M25 Junction 28

From: Huya [REDACTED]
Sent: 13 May 2021 15:39
To: M25 Junction 28
Cc: Hanlon, Paige; Mawdsley, Edwin
Subject: Comments to ISH 3 on Wednesday 12 May 2021 from Jane Allan [REDACTED]
[REDACTED] for Deadline 7

Drawing Title: **TEMPORARY TRAFFIC MANAGEMENT
A12 EASTBOUND ON SLIP ROAD CLOSURE
DIVERSION ROUTE**

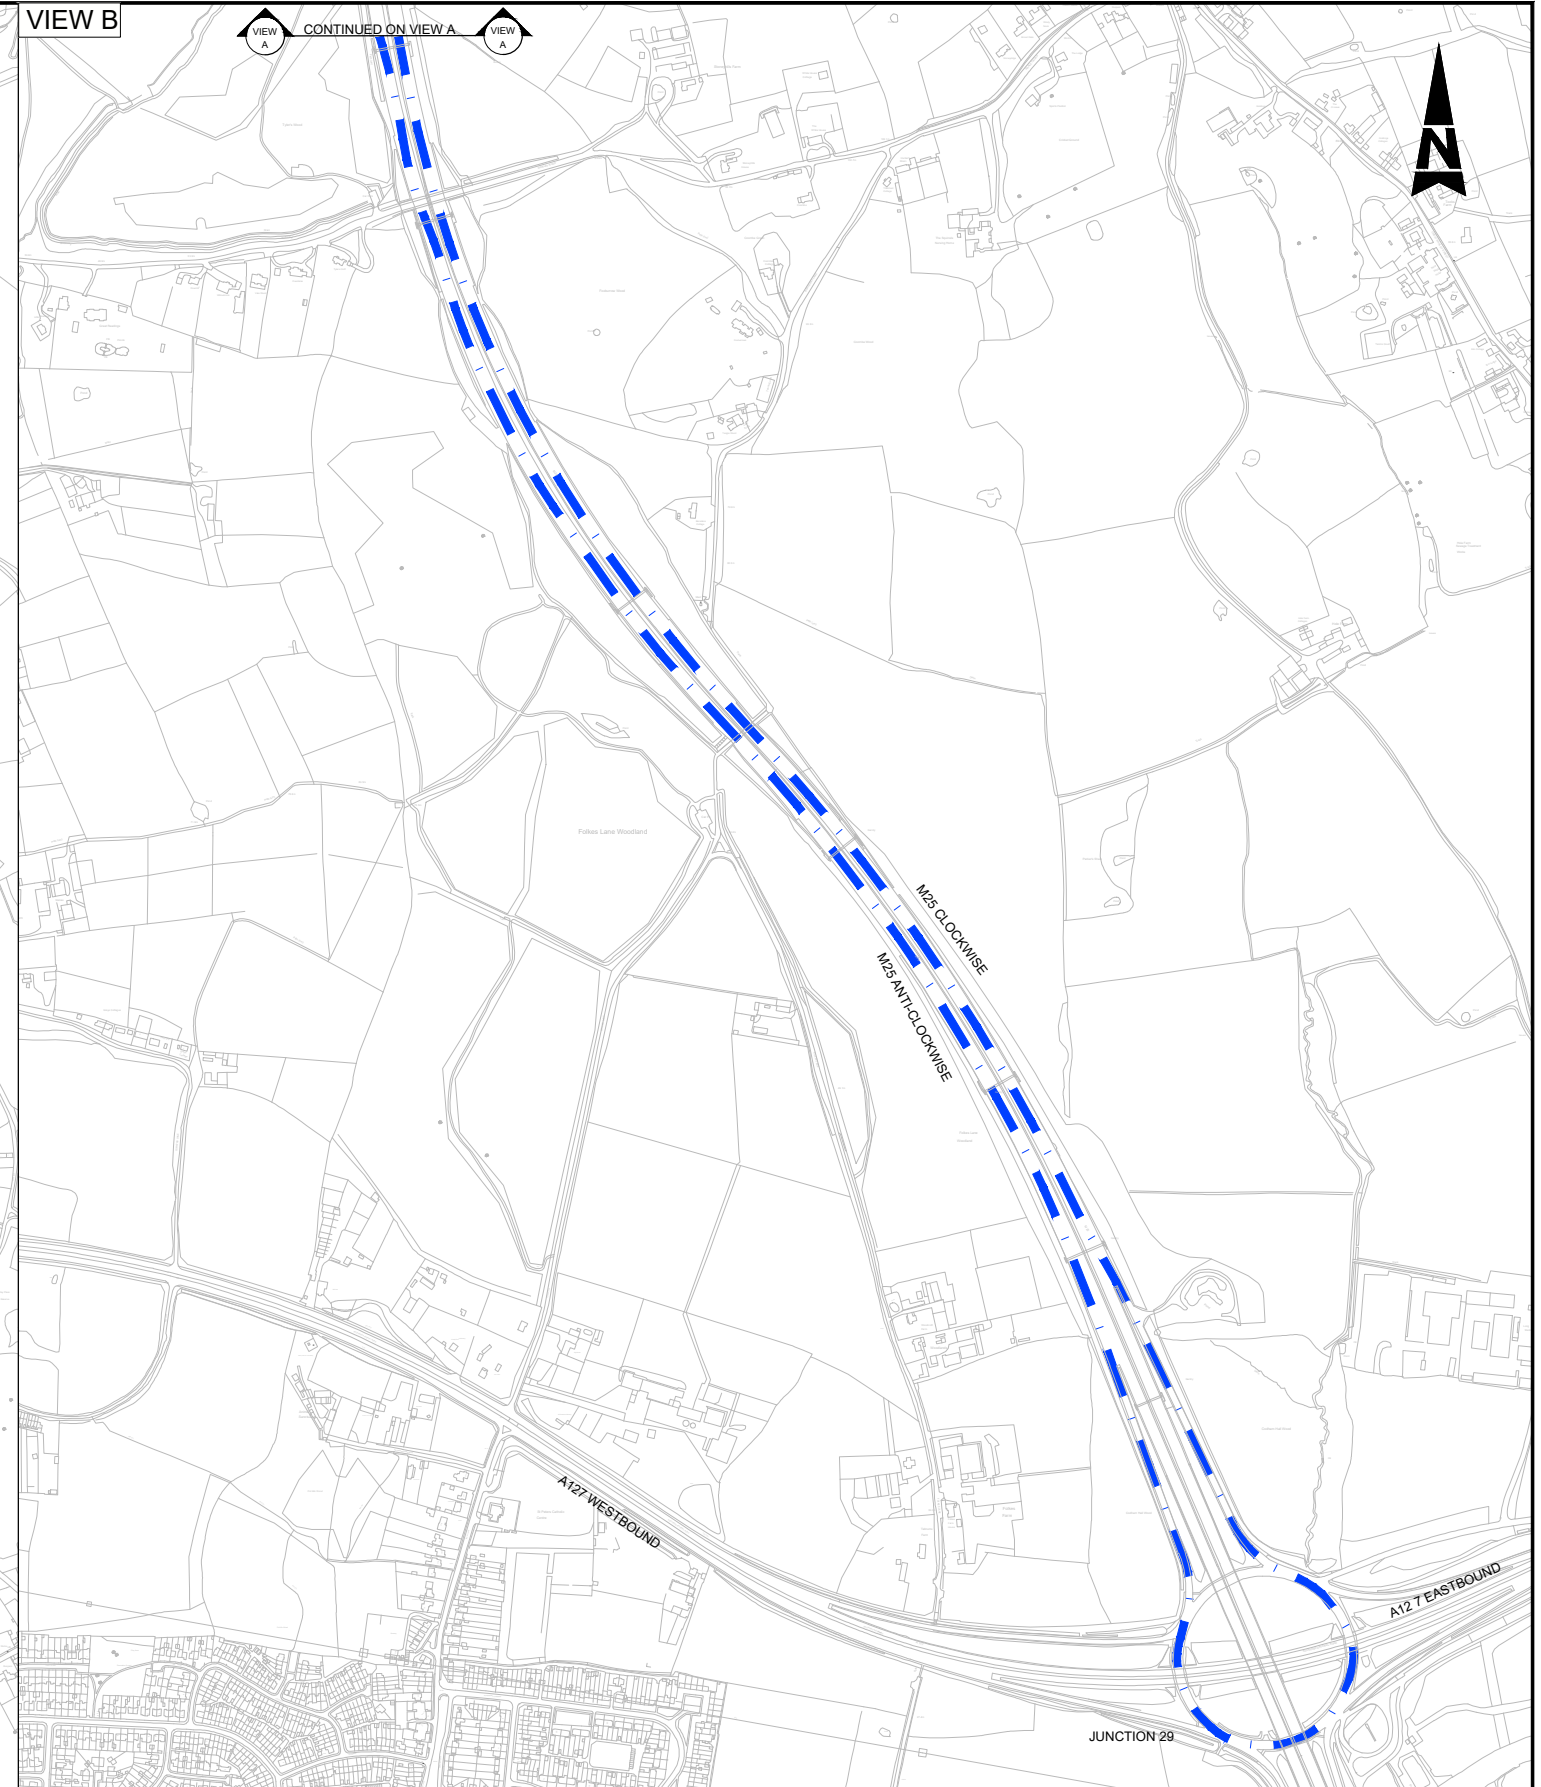
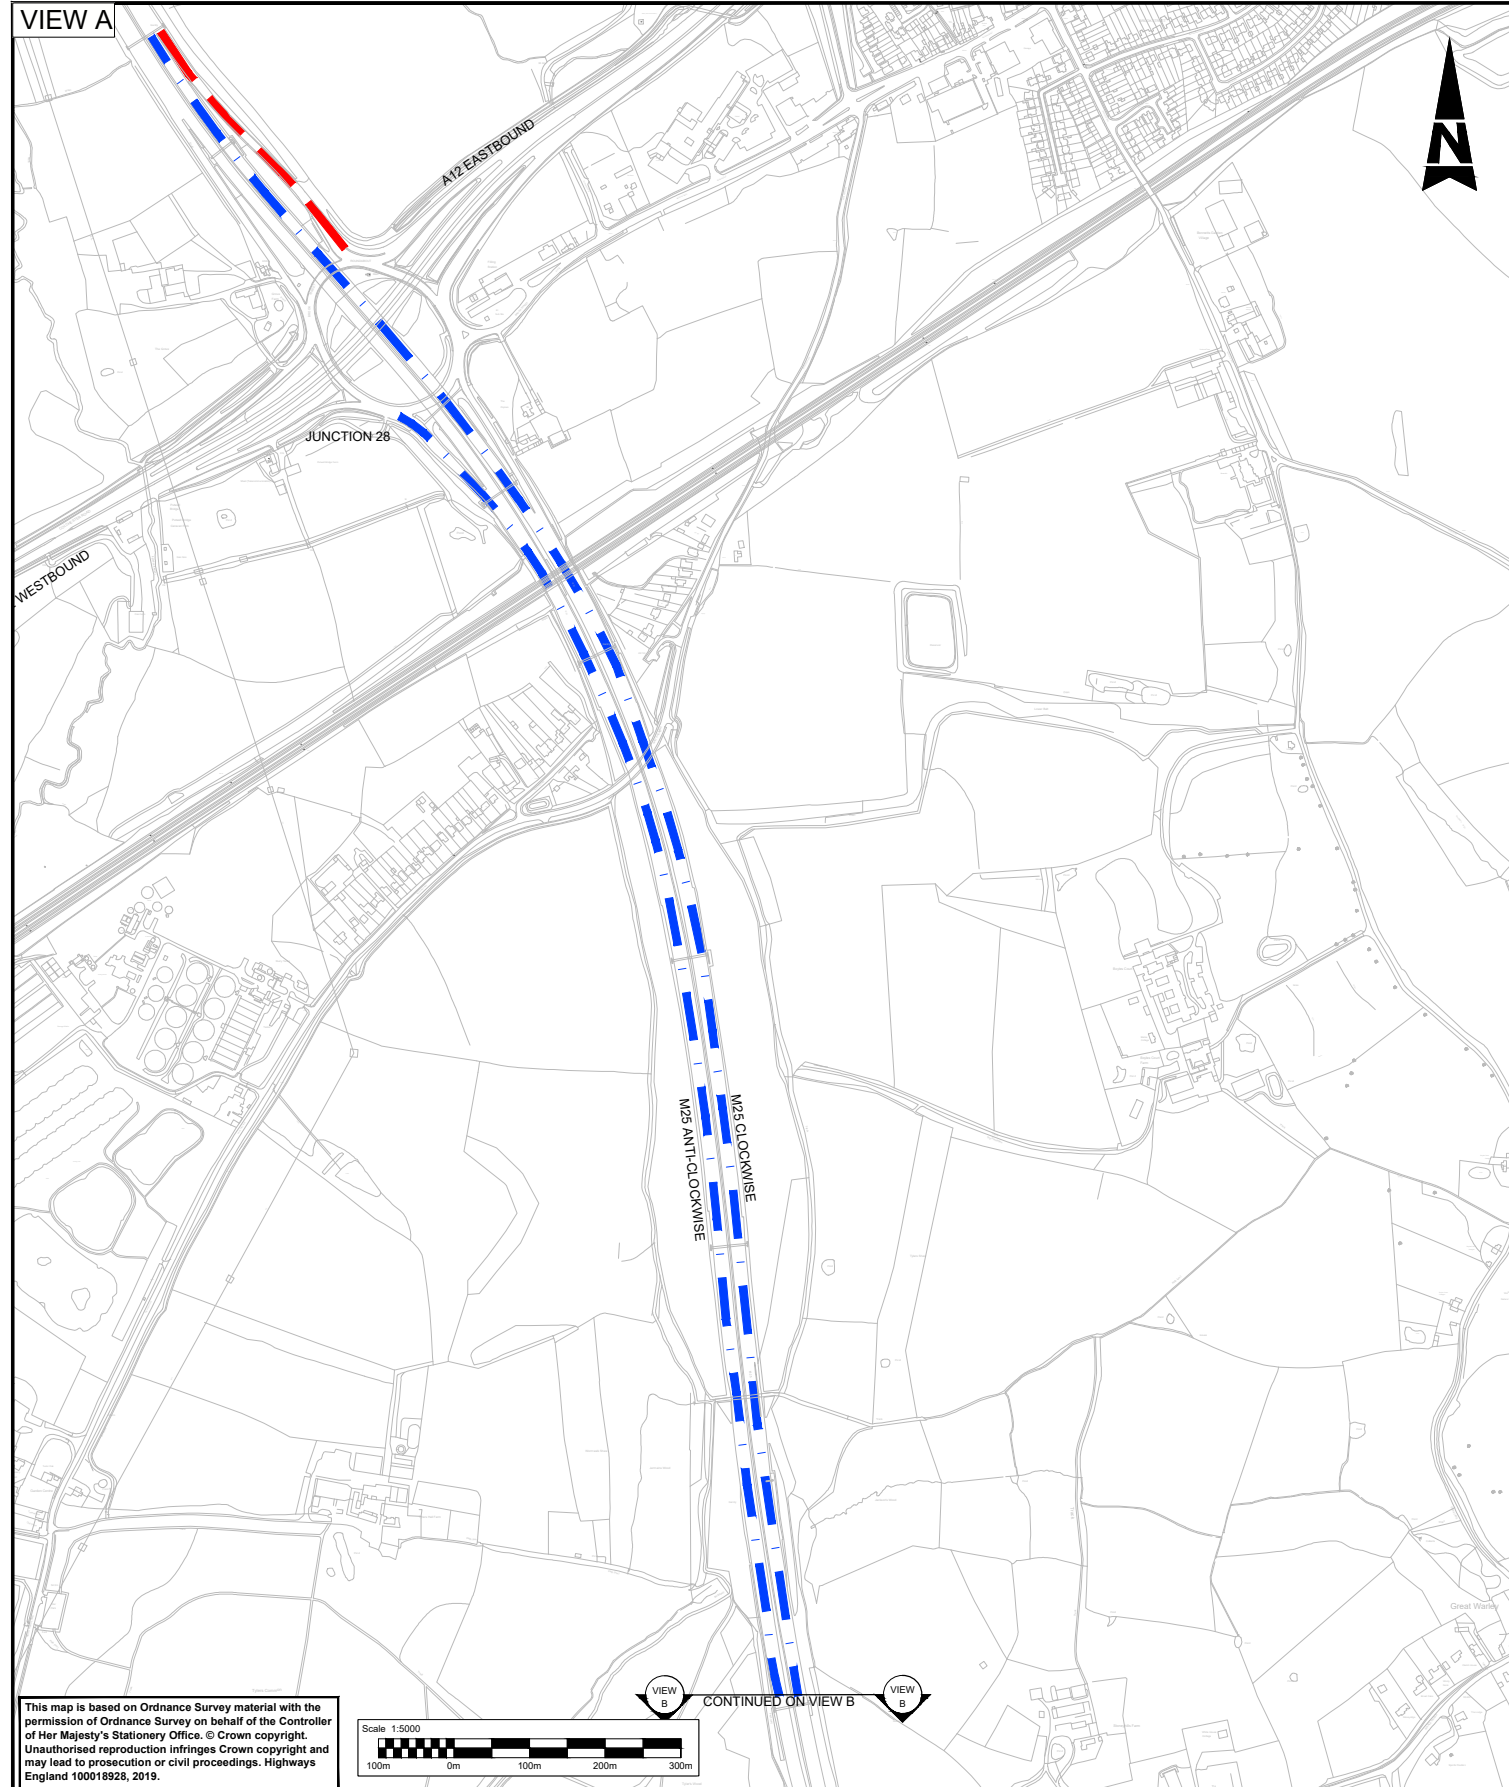
2. The outline TMP does not meet the needs of residents in Woodstock Avenue (WA). As previously highlighted on multiple occasions in writing and verbally it is unacceptable to expect residents of WA to make diversions to the Shenfield junction along the A12 to travel westbound when the A12 off slip is closed during the construction phase of this project. In addition to the temporary (not defined) A12 off slip road closures other proposed diversions and delivery of construction materials throughout this project will impact residents of WA significantly more than other residents in this area which is why the TMP should facilitate the inclusion of a right hand turn between WA and the M25j28 off slip.

Drawing Title: **PETERSFIELD AVENUE
CONSTRUCTION TRAFFIC U-TURN
SWEPT PATH ANALYSIS
ARTICULATED VEHICLE**

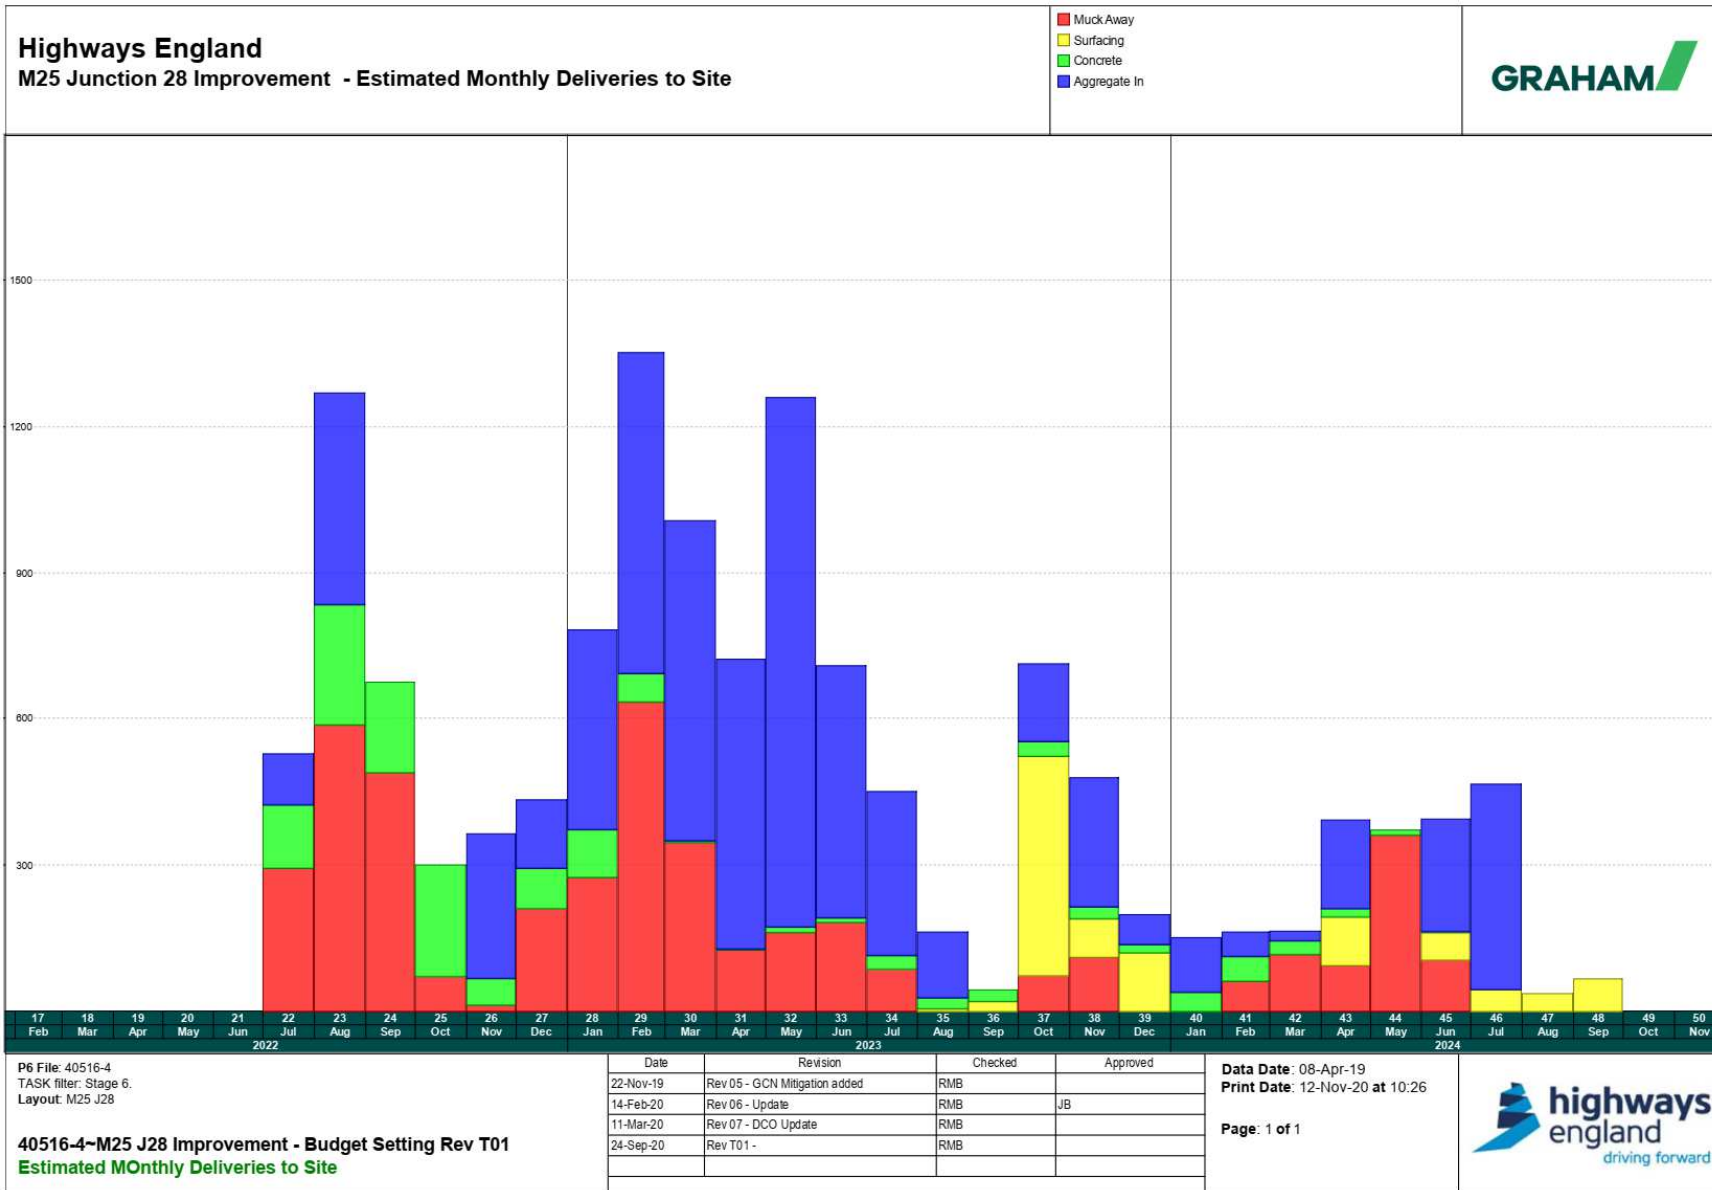
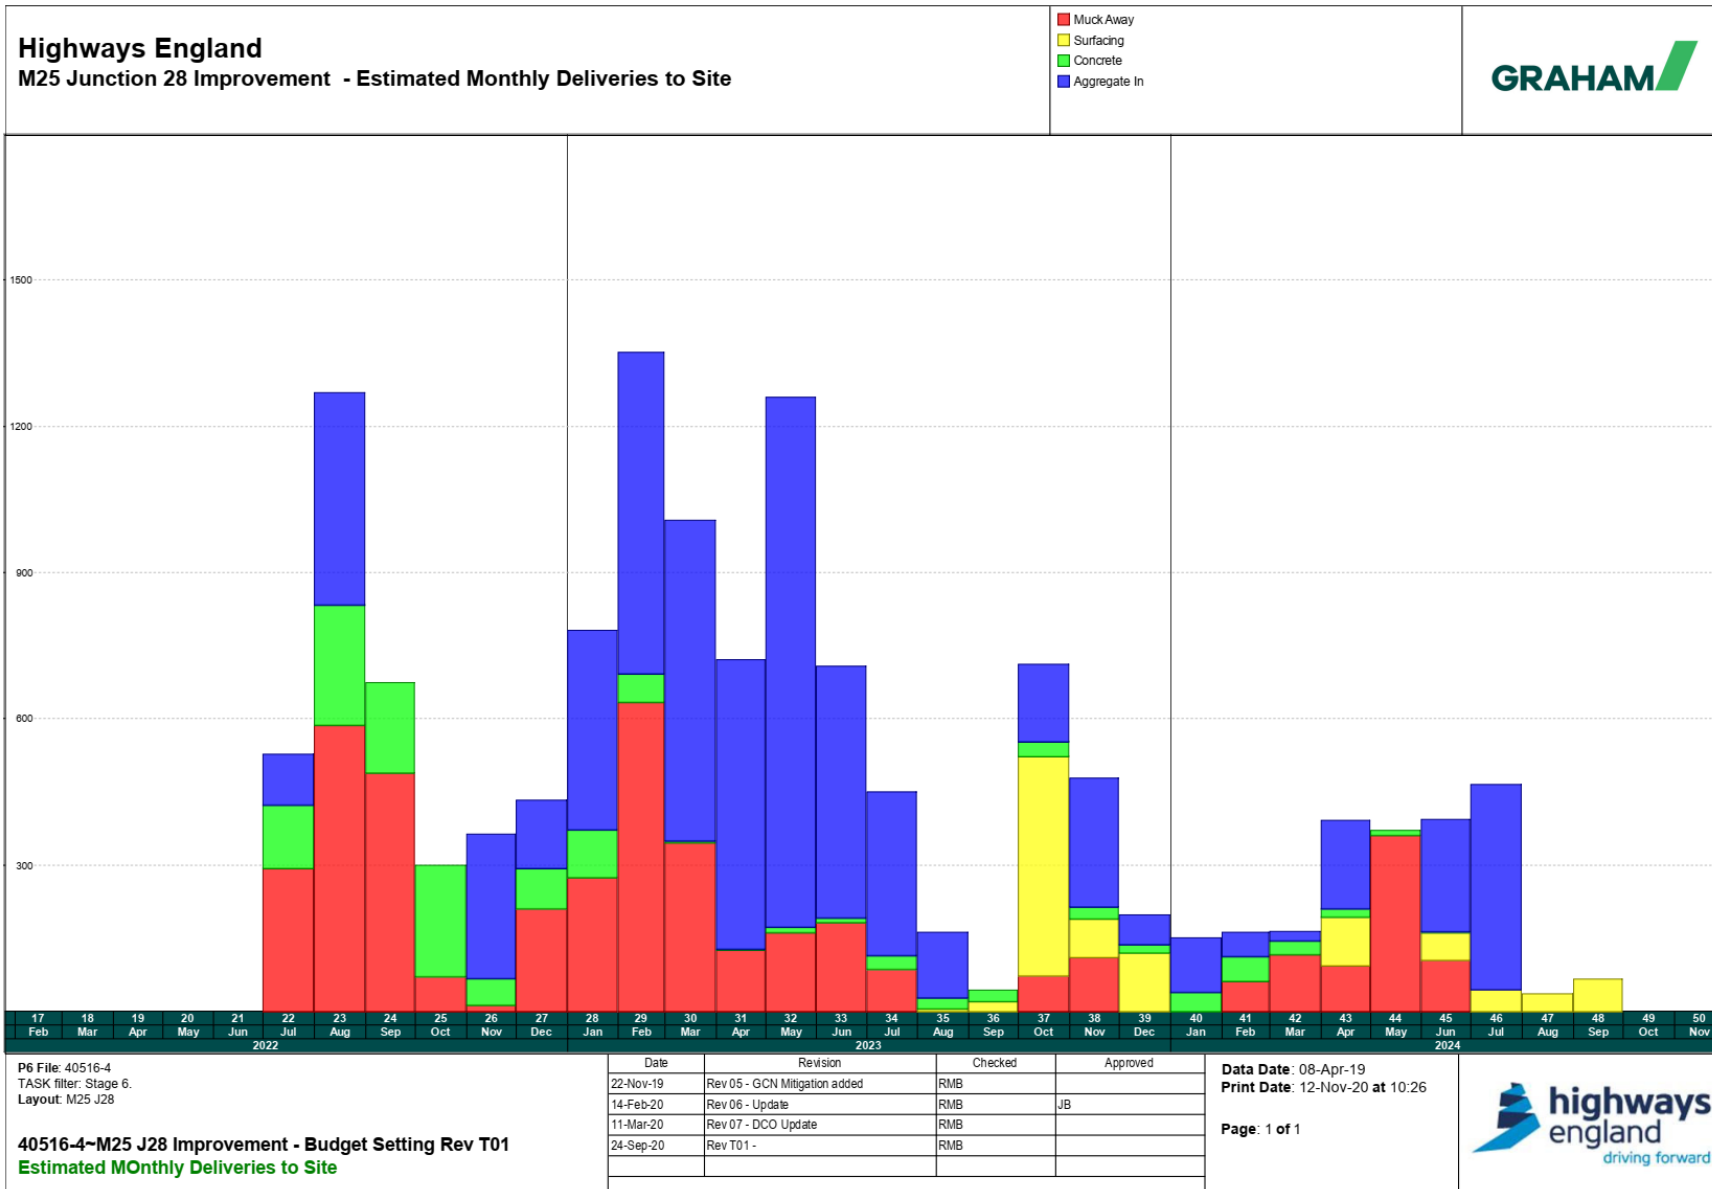
4. HGVs should be prohibited (and monitored) from making U turns along the A12 at Petersfield Avenue during the construction phase. Traffic lights at this junction have been knocked down on several occasions by large vehicles trying to make U turns here.
